CITY OF ALBUQUERQUE

April 10, 2017

RE: Mesa Cold Storage
Grading and Drainage Plan
Engineer's Stamp Date 4-6-2017 (File: H13D108)

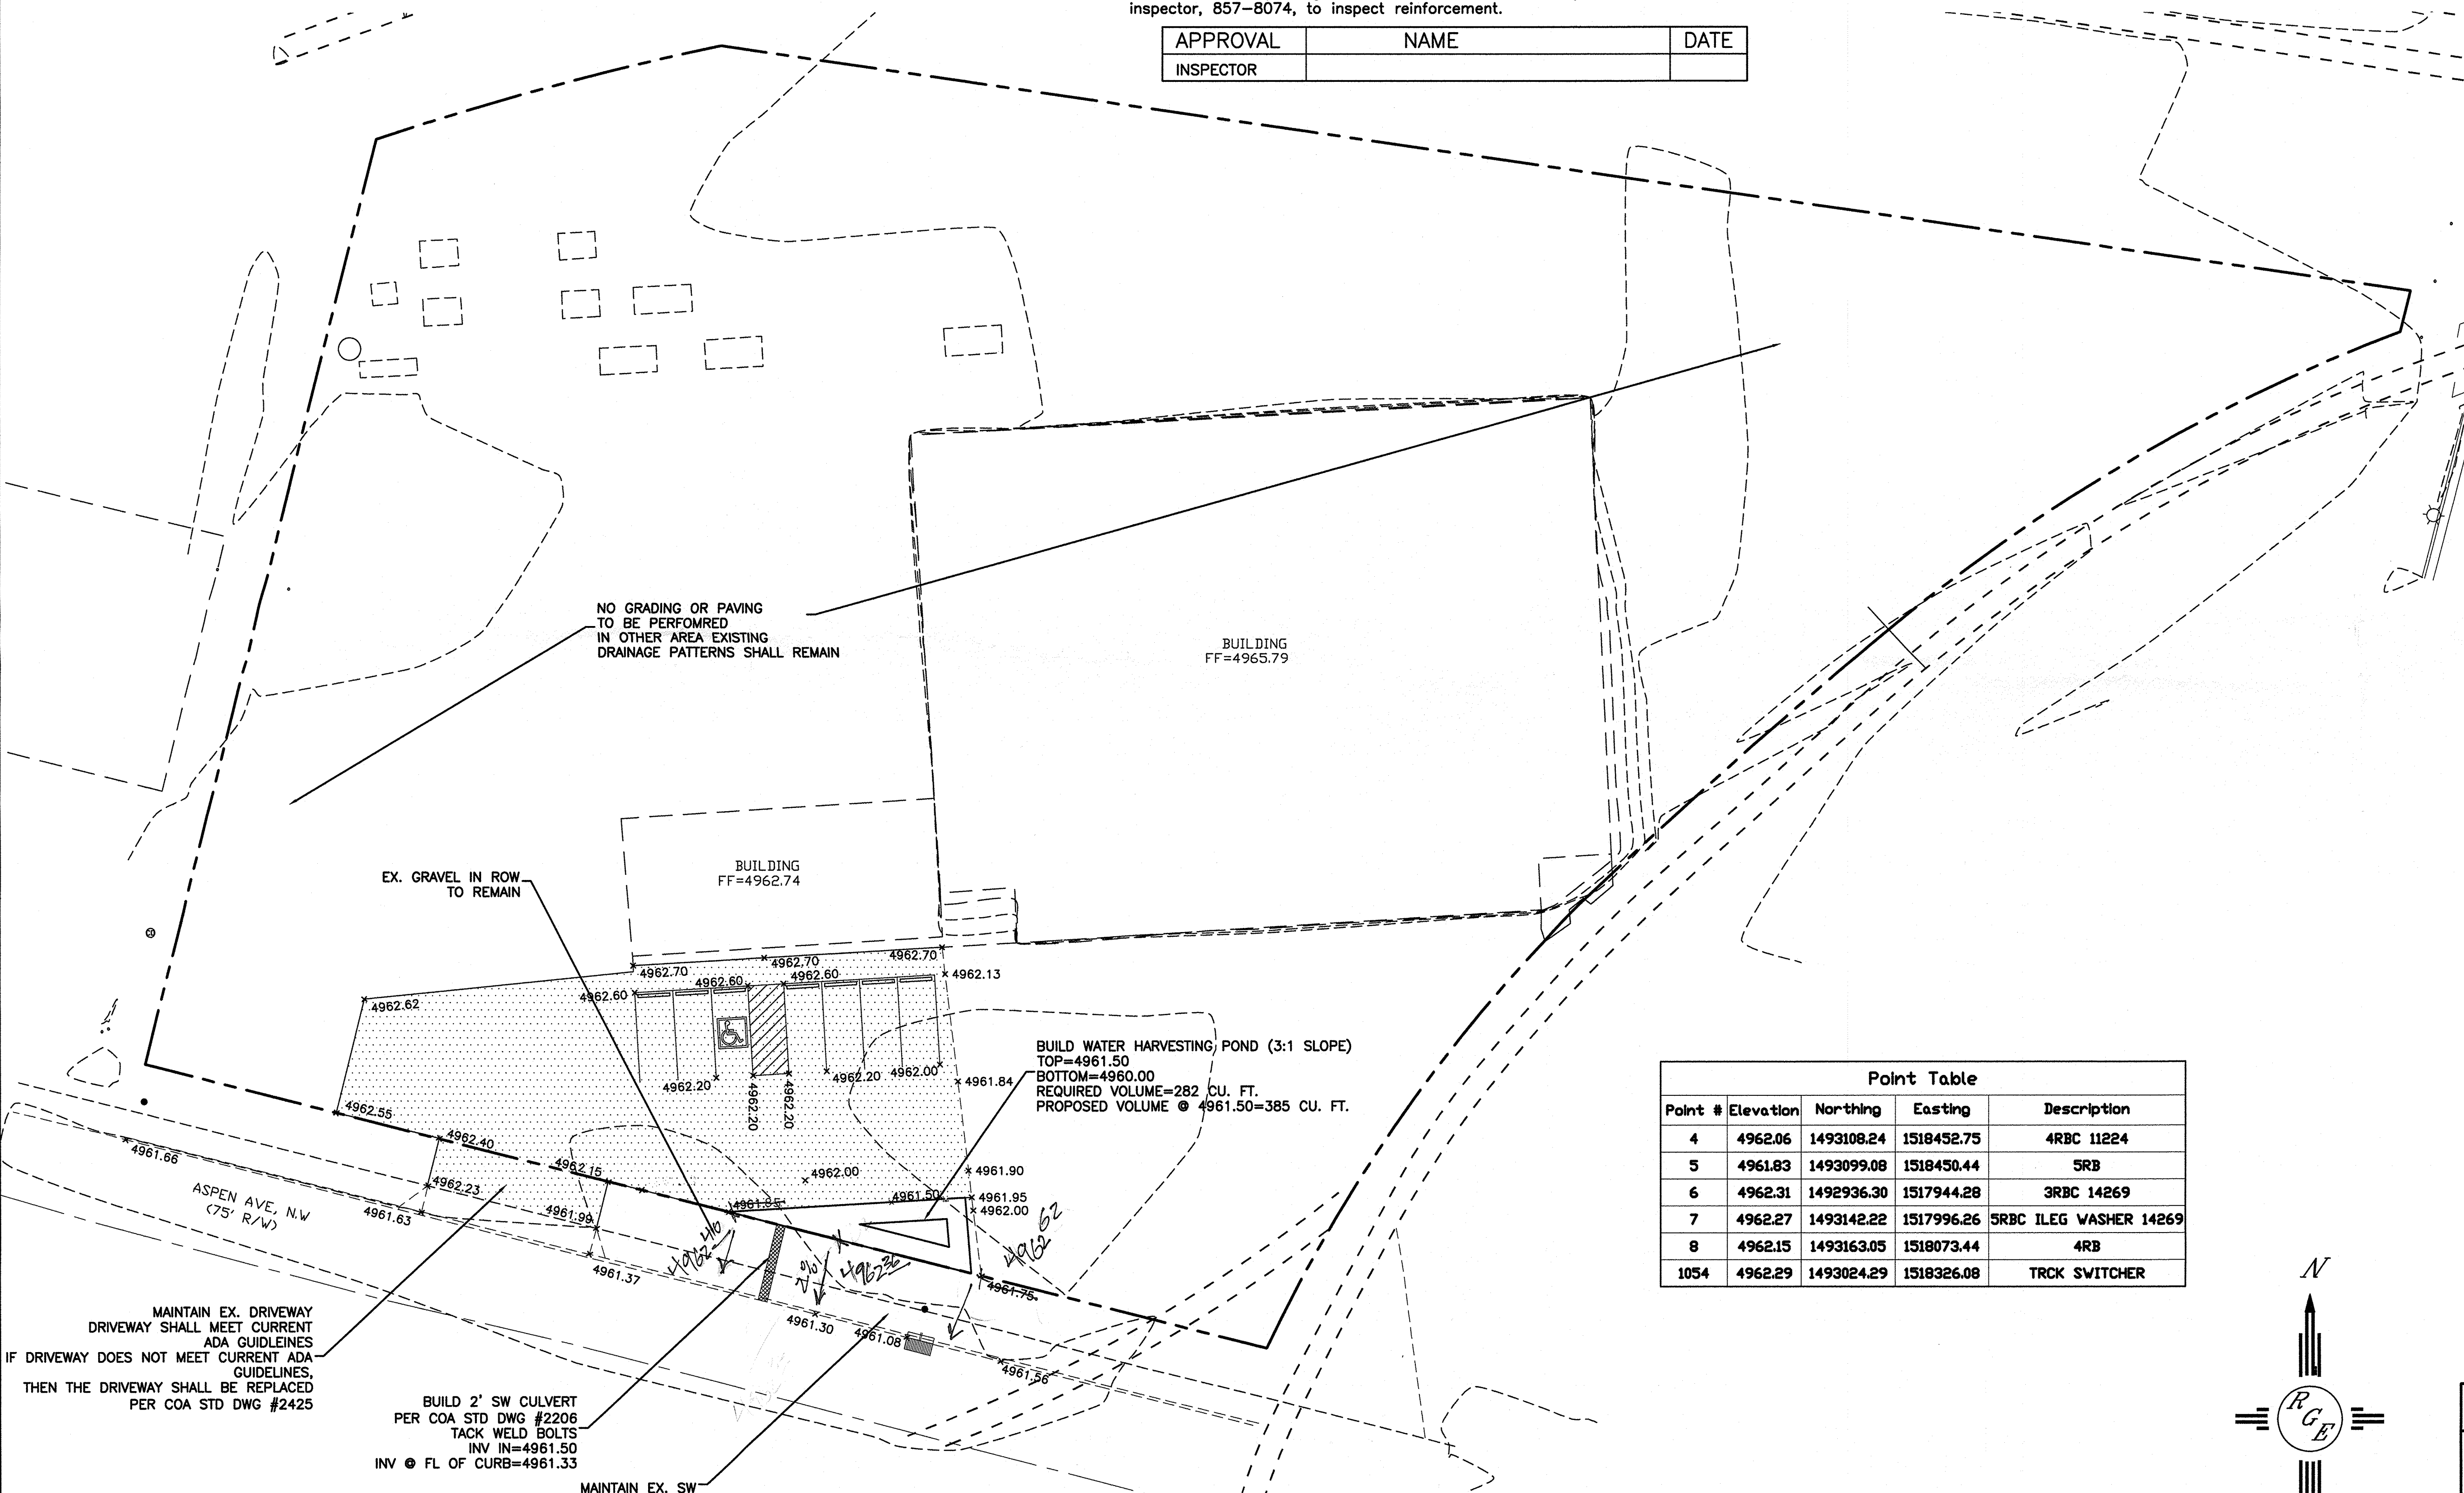
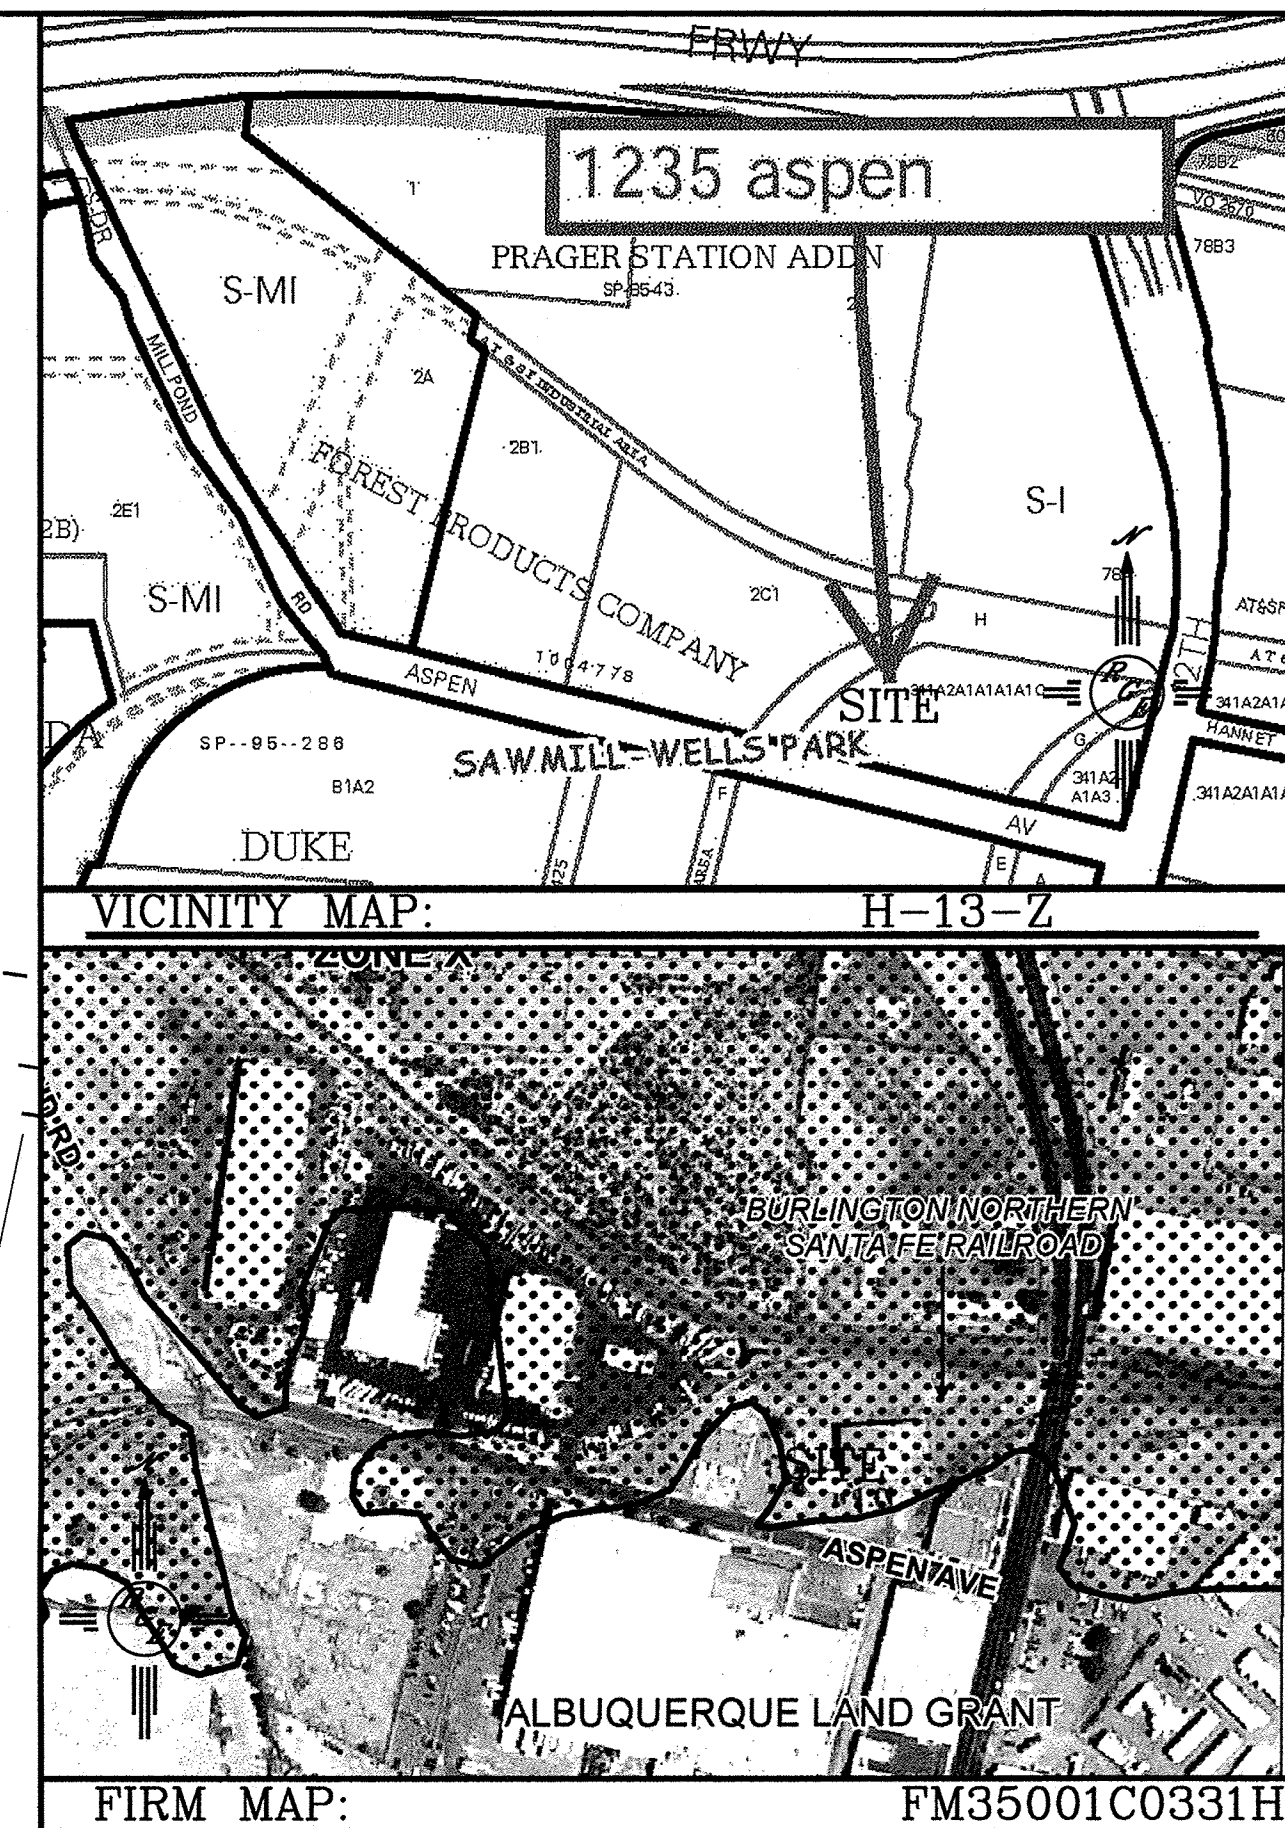
- Change the grade from 4961.14 to +/- 4962.36.
